DEVELOPMENT REVIEW BOARD
TRANSPORTATION DEVELOPMENT

DRB Project Number: 1009243
Taco Bell - Girard

SUBJECT: Sketch Plat

DRB Project Number: 1009243 Hearing Date: 03-14-2018
 Project: Monte Vista Addition, Lot 2A-1, Blk 12 Agenda Item No: 13

Replat of
 Lot 2A-1, Block 12
Monte Vista Addition
 Section 22, Township 10 N., Range 3 E., N.M.P.M.
 Albuquerque, Bernalillo County, New Mexico
 January 2018

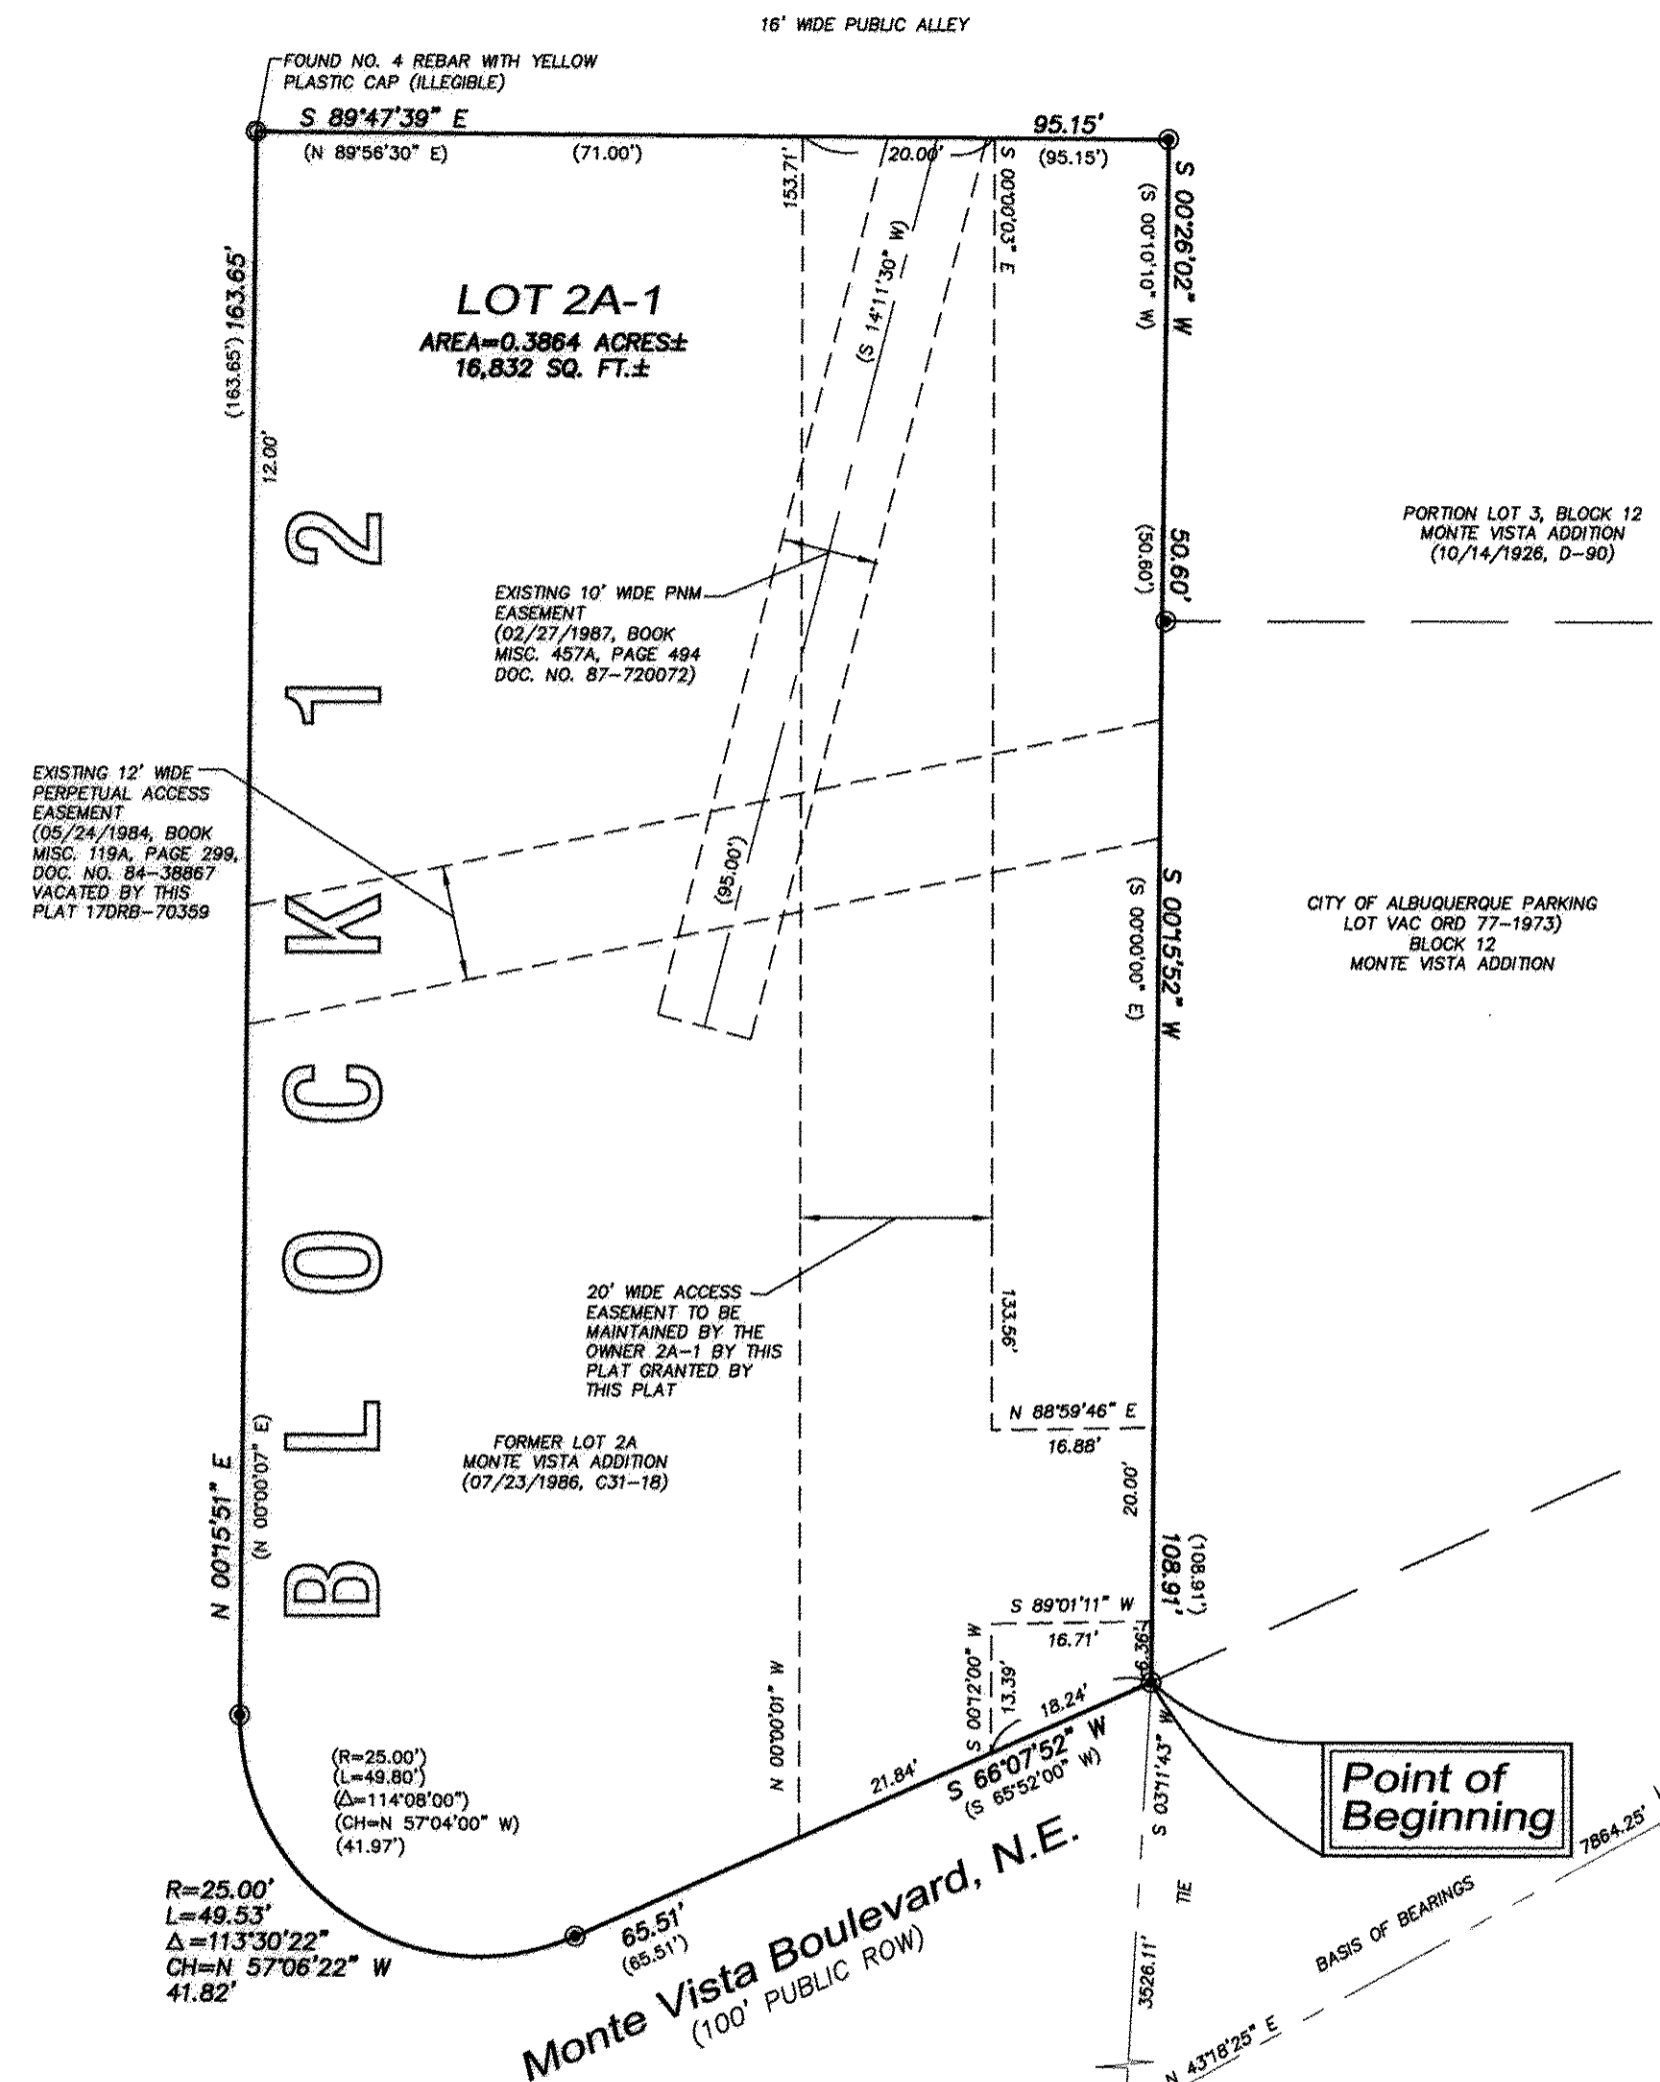
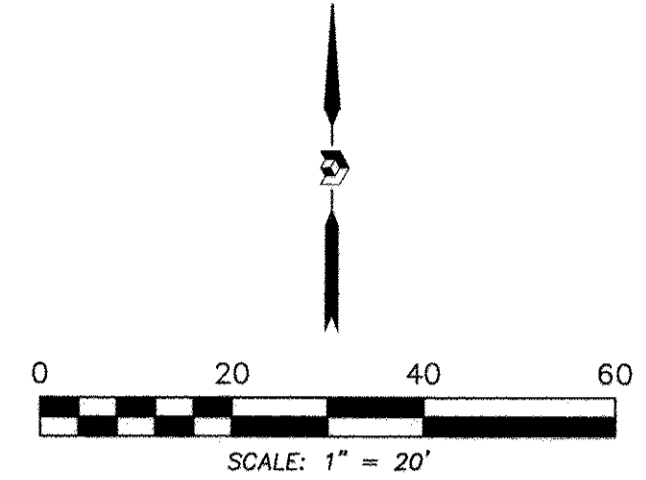
1. Show vacation information of access easement.
2. Provide a new cross access easement.
3. For final plat, any access easements need to be shown with all beneficiaries and maintenance responsibilities listed.
- ~~4. Provide site plan showing proposed easement lines.~~

Is the access easement private or public (assuming public)? Please add to description on plat.
